Application No: AL/42/21/HH
Site Address: 32 Lime Avenue Westergate Chichester PO20 3UF
Description of works: Erect a fence along the east side boundary

Thank you for your internet representation made on 1st June 2021 which has been recorded as an objection with the comments as follows:

Proposed Fence Line
Marked in Red

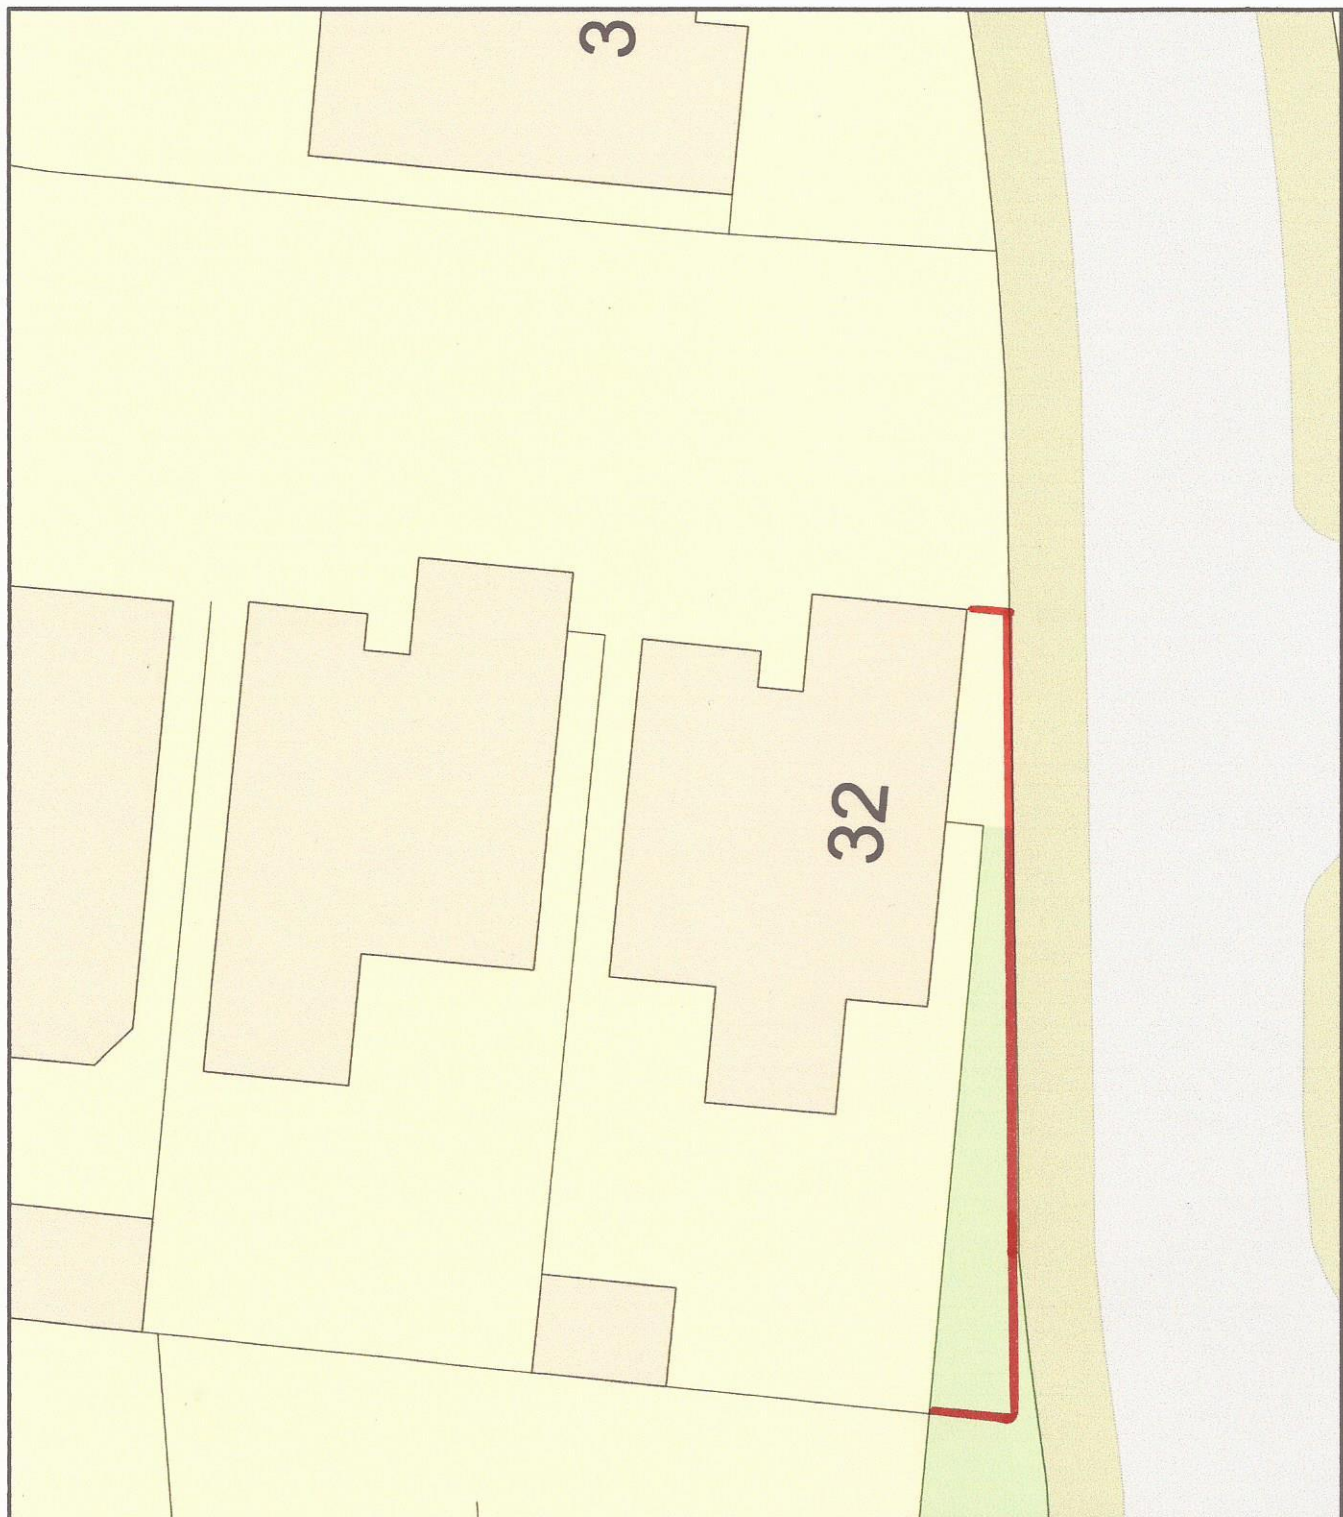
The proposed fence is a serious departure away from the existing combination of wooden panel and brick boundary fence that is currently in situ. In addition, it will 'jut out' (as seen in the proposed plans), and will therefore, no longer form a distinct boundary with house no. 31 and may potentially be a visibility hazard for motorists and pedestrians. It could also mean a narrowing of pedestrian access should cars park on the pavement as they often do in this part of the road. Previously, we have had access issues for emergency vehicles wishing to enter Lime Avenue and School Close so anything which narrows the road even further should be avoided.
